CITY OF ALBUQUERQUE

**Re: 8801 Glendale Blvd NE,
Request for Permanent C.O. –Accepted
Engineer's Stamp dated: 10-8-13, (B20D021)
Certification dated: 12-3-13**

**Re: 8801 Glendale Ave NE, Grading and Drainage Plan
Engineer's Stamp Date 10-8-13 (B20D021)**

**Re: 8801 Glendale Ave NE, Grading and Drainage Plan
Engineer's Stamp Date 10-8-13 (B20D021)**

CULVERT INLET DETAIL

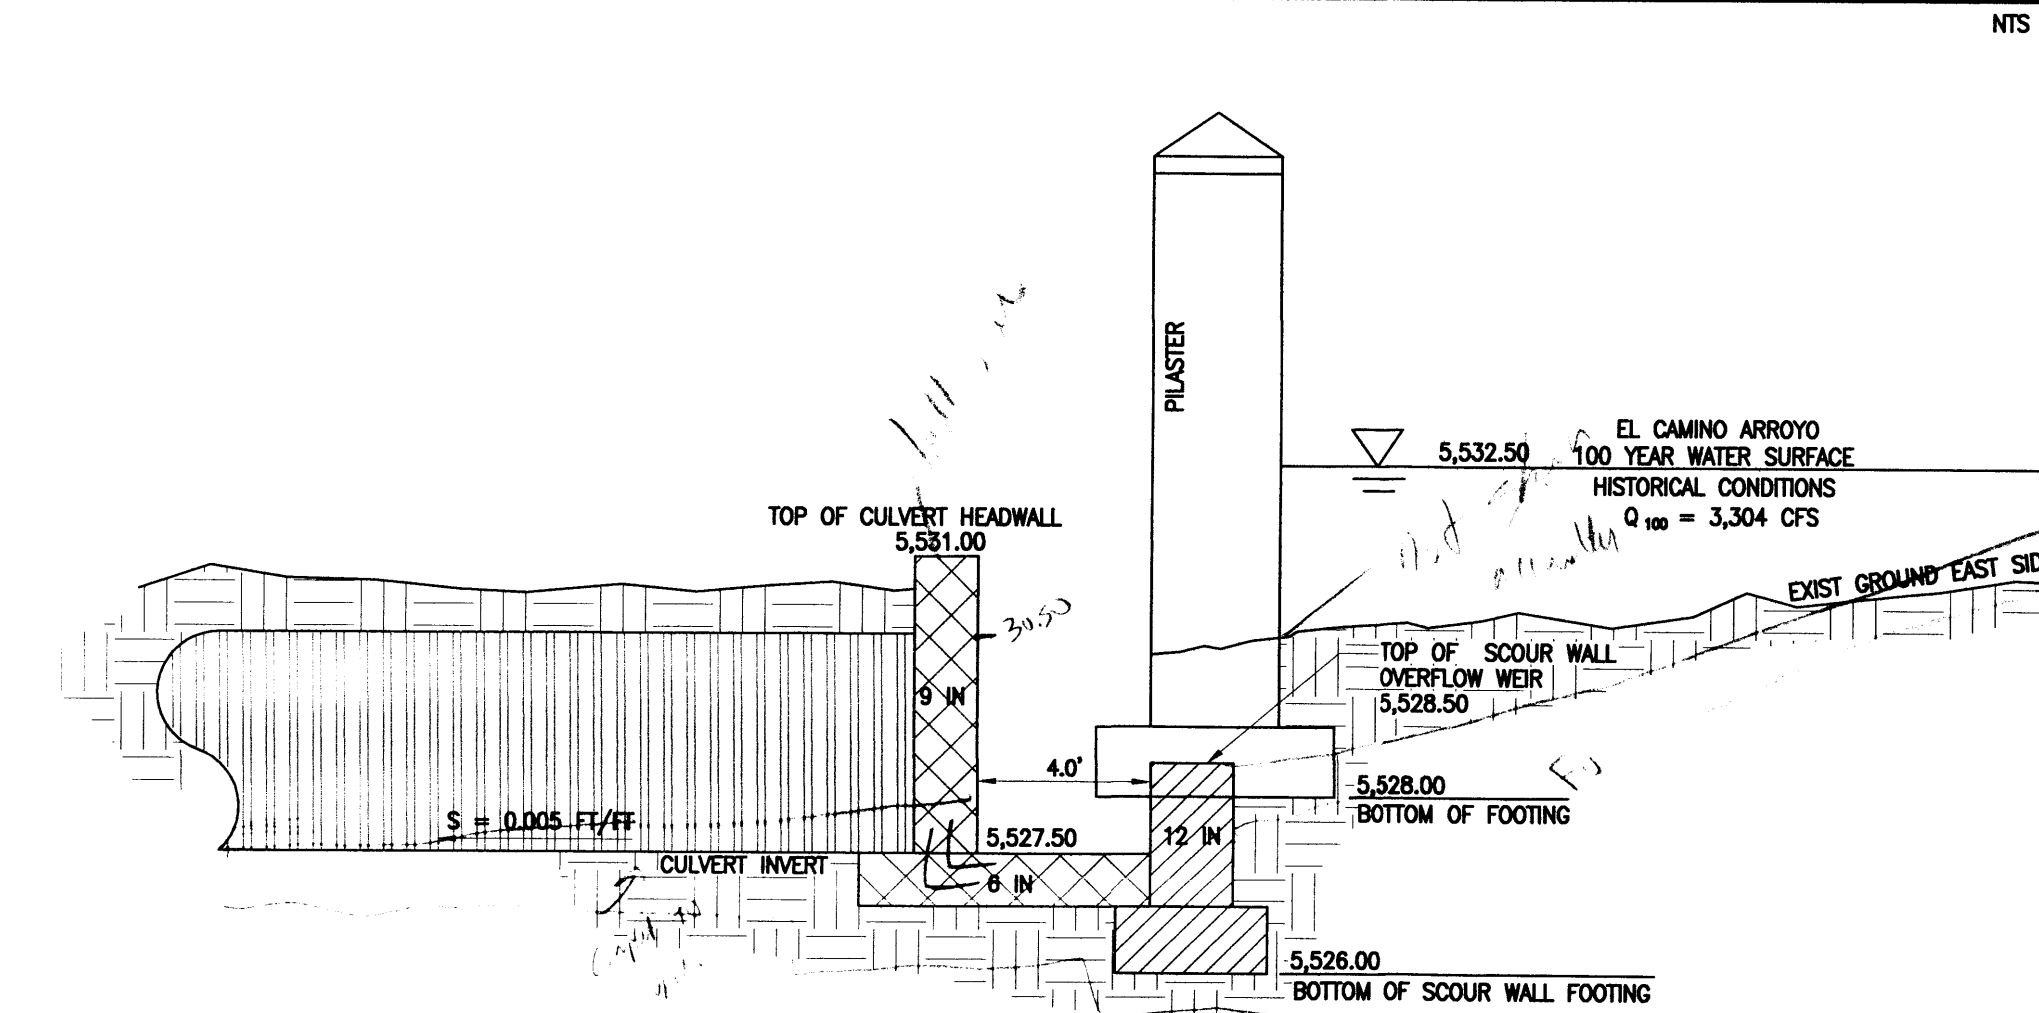
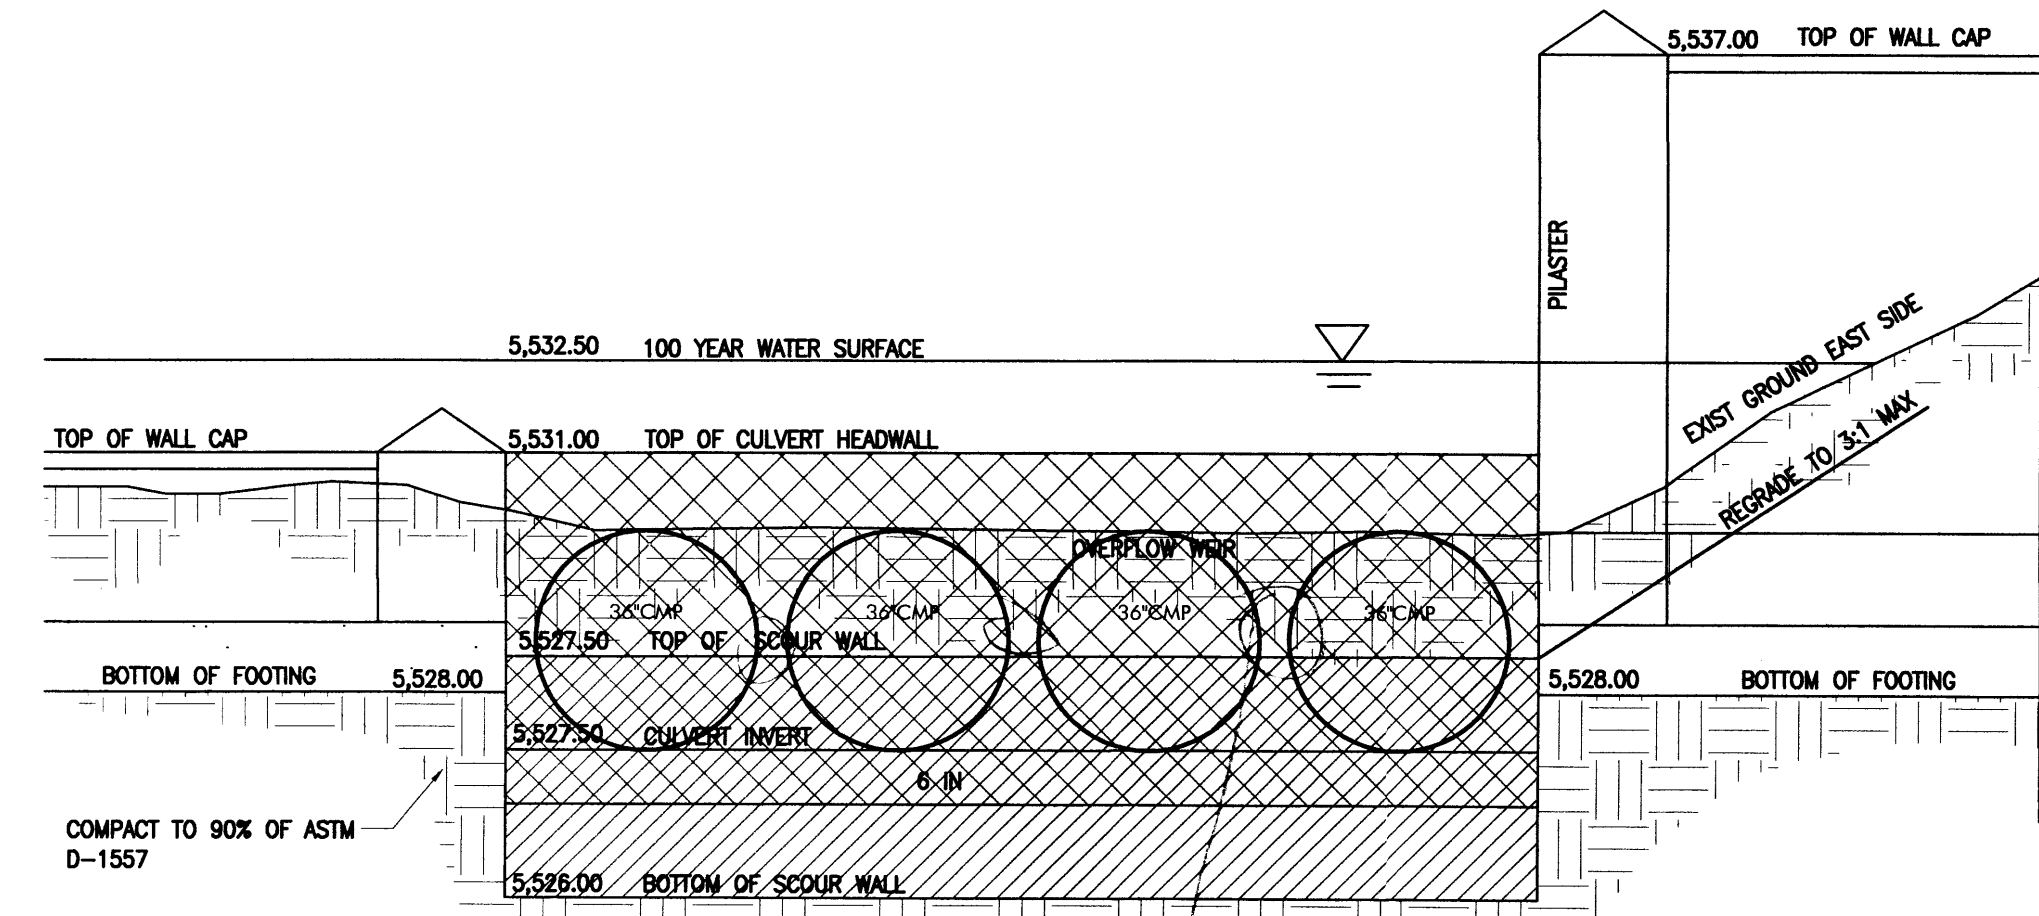
1. Per our meeting October 4th, the height of the inlet weir was discussed and the elevation of 28.5 was agreed to by all parties present. Parties present were, myself, Bryan Wolfe, Gary Padilla and you. The 28.5 elevation was agreed to because that was the predevelopment invert elevation of the arroyo. Why would you then submit a plan with an inlet weir elevation of 29?

If the reason for the 29 elevation is to protect the footers of the existing wall, it is acceptable to have the elevation of the inlet weir at 29 for a couple feet in from each footer, then cut a taper down to the agreed upon 28.5 elevation for the remainder of the inlet weir.

not a
1. Per a site visit on 9-23-13, the invert of the channel is approximately 5527.5, assuming the elevation of the bottom of the footer on sheet 2 of 2 is correct. This elevation may have dropped from the existing grade shown on the approved grading and drainage plan of 5528.64, Thames Engineering and Design stamp date 9-1-11.

a. Revise the culvert inlet Detail on Sheet 2 of 2 to show the existing arroyo invert (approximately 27.5) and the predevelopment arroyo invert (approximately 28.6). The "Exist Ground East Side" grade is shown too high.

8. Revise the inlet weir INV from 30.00 to 28.5 or just remove the note since the Top of Scour wall elevation is the inlet weir elevation.

DRIVEWAY CULVERT SECTION B-B

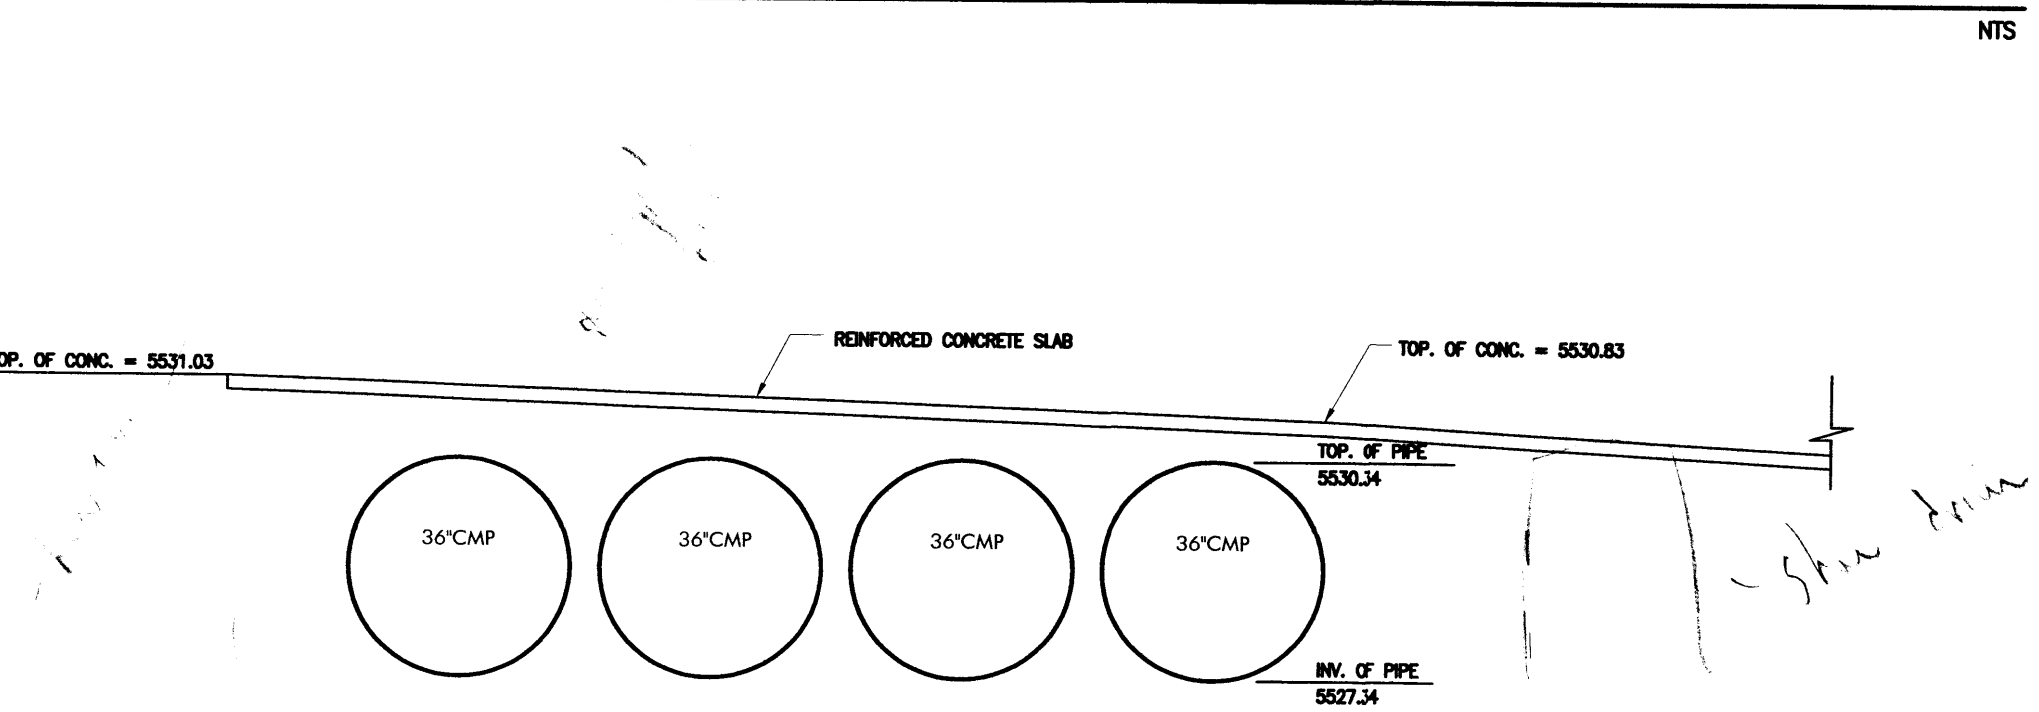
2. Show the existing driveway, vertical walls and the ground beneath the pipes in the driveway culvert section B-B. Include spot elevations for Top of Concrete on the south and north sides. There is an existing TOC of 29.03 at the southwest corner where the CMPs go under the driveway. This appears to be a conflict with the pipes.

4. The compaction note is in a place where compaction is not required. A more appropriate location would be the culvert inlet detail or section B-B.

5. The Driveway culvert Section could be omitted as it is not necessary. IF you wish to keep it, amend the minimum cover dimension to reflect the actual minimum cover.

CULVERT INLET DETAIL

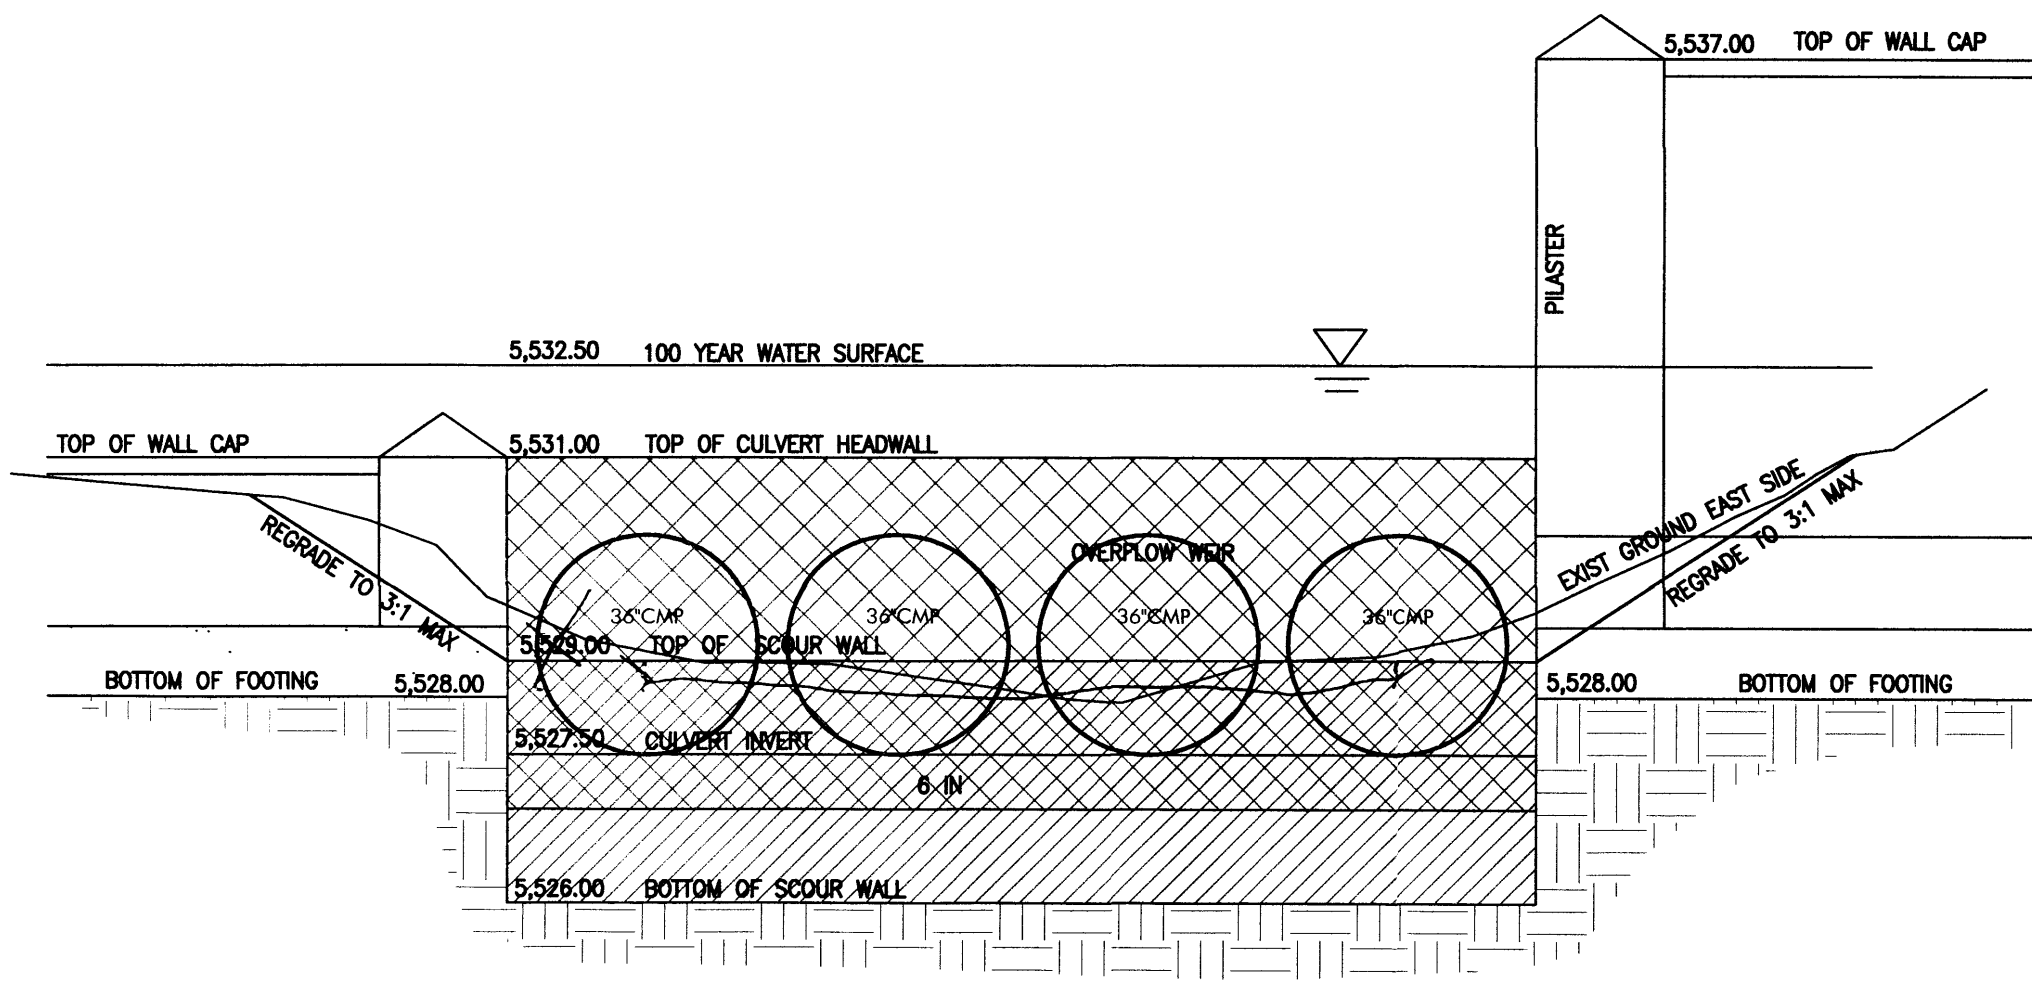
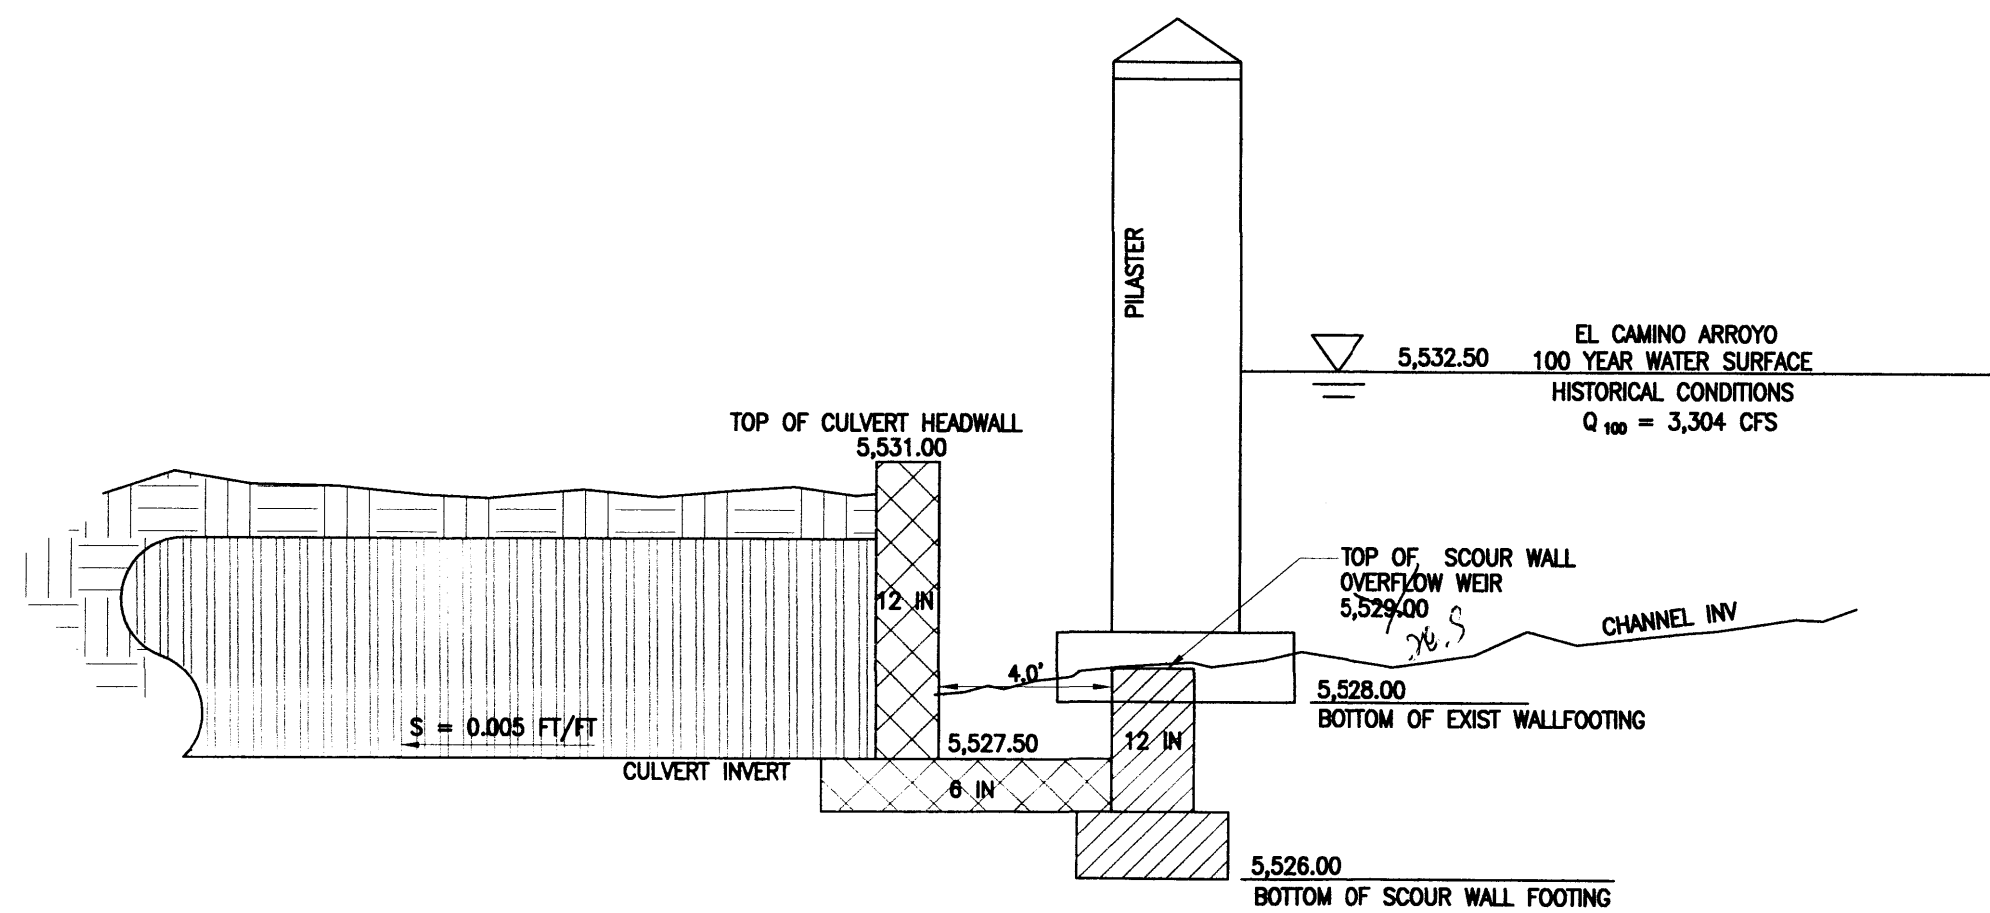
Revise Sheets C1 and C2 to reflect the above comment.

2. The following comment was provided in the letter dated October 7th, 2013 and was not addressed: The culvert headwall should be tied into the concrete below it so it doesn't fall over due to the load above it.

The overflow weir elevation that I originally called out was at elevation 30. This was due to the fact that the historical 30 contour hit each edge of the overflow weir location. We proposed to backfill the arroyo up to the 30 contour to provide a nice even overflow into the box. This would also provide a bit of protection for potential headcutting into the property to the east. When we discussed the 28.5 elevation for the overflow weir, that was based on your old survey from Tim. The survey that was provided to us did not reflect that elevation. When assessing the elevation in the field, we found that the 28.5 elevation for the overflow weir was below the adjacent wall footings and that we couldn't tie in to it so we raised it to elevation 29. We were able to tie rebar into the existing wall footings to help support the new scour wall. There is absolutely no detrimental impact or reduction in capacity to the upstream property by doing this. It also provides protection from headcutting into the adjacent property. We would consider this construction as an improvement and a justifiable stabilization to the existing flowpath due to the propensity of scour throughout the area. By cutting the weir down to the 28.5, we will be exacerbating the upstream scour. Placing drop structures within arroyos is a common practice to reduce scour, by virtually reducing the channel slope. This wall will function as a drop structure and it functions well at the elevation constructed and will provide additional scour protection for the upstream property. The design flow of 3,304-cfs will still be about 2.5 feet above the overflow weir. It will still be travelling at about 11-fps. Opening the wall section and clearing the vegetation will increase the historical capacity. Reducing the overflow elevation by an additional six inches will not significantly impact the hydraulics of the system and will increase the upstream headcutting potential. I'm sure that Mr. Padilla won't have an issue cutting the wall to whatever elevation you would like. It's totally your call.

The scour wall is four feet deep. It extends down four feet from the backfill on the eastern side of the wall. It was designed and built as a four foot retaining wall with a 24 inch footing and required rebar within the footing and the wall. The culvert headwalls were also constructed with footings and rebar tied into the tops and sides of the walls. The headwalls were also poured 12-inches thick instead of the nine inches called out.
